20 January 2022

**Council Reference: REQ15905/2021**  
**Bass Point Quarry (MOD 3) - Amenity barriers (MP08\_0143-Mod-3)**  
**Boollwarroo Parade Shell Cove NSW 2529 Lot 22 DP 1010797**

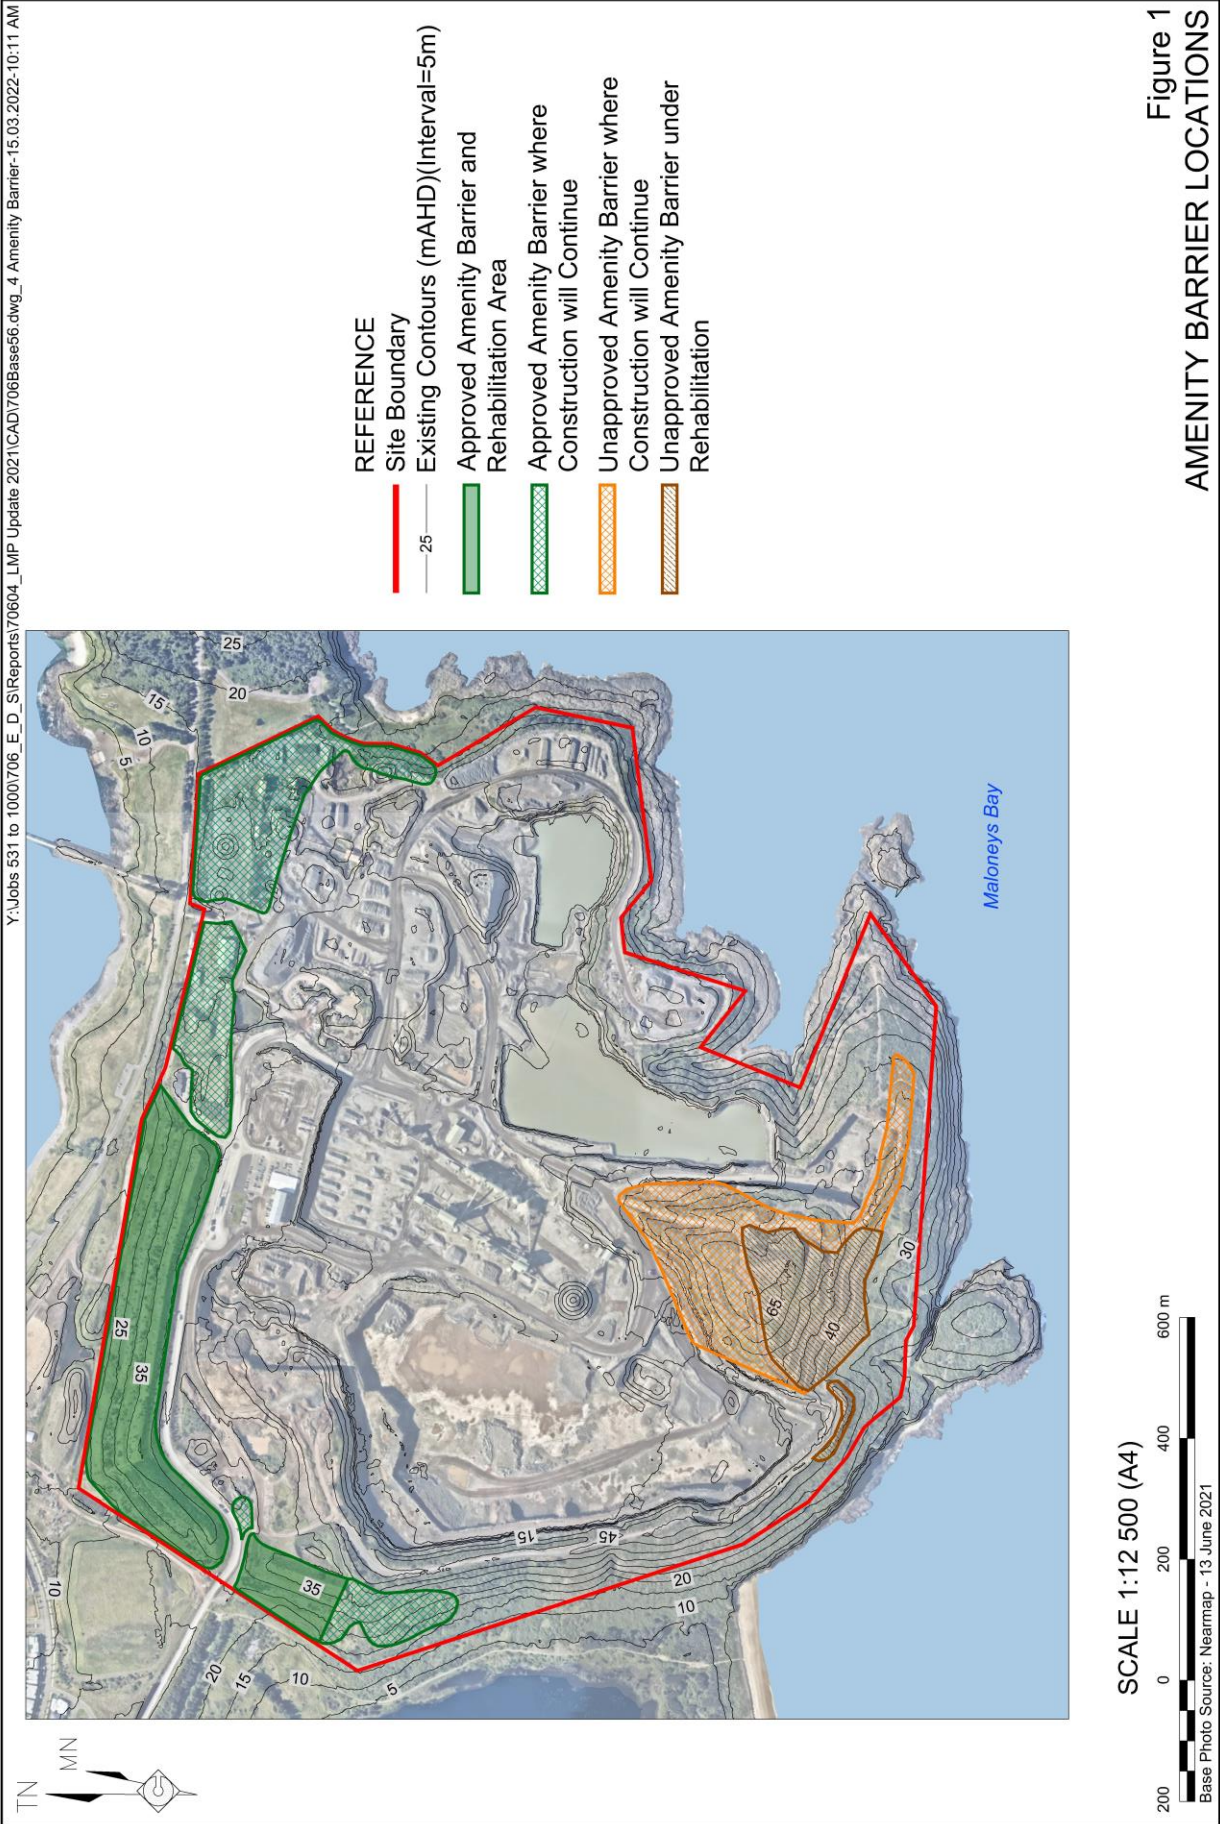
- Amended plans which clearly show the existing and proposed contour levels across the areas the subject of this modification (note that the submitted plans are not provided at a resolution which allows for the reading of the contour lines).

- Amended plans which clearly identify what amenity barriers exist on the site currently, what additional amenity barriers (or additional height to be added to existing barriers) are proposed to be constructed at the site and what parts, if any, of the existing amenity barriers have current development consent.

- Additional information which clarifies whether the screen mounds noted on the 'Approved Quarry Layout Plan' as being 30m AHD and 40m AHD along the northern boundary of the quarry are existing and have been constructed to the approved heights.

- Amended plans which clearly identify what rehabilitation areas have development consent and which are proposed as part of the modification request.
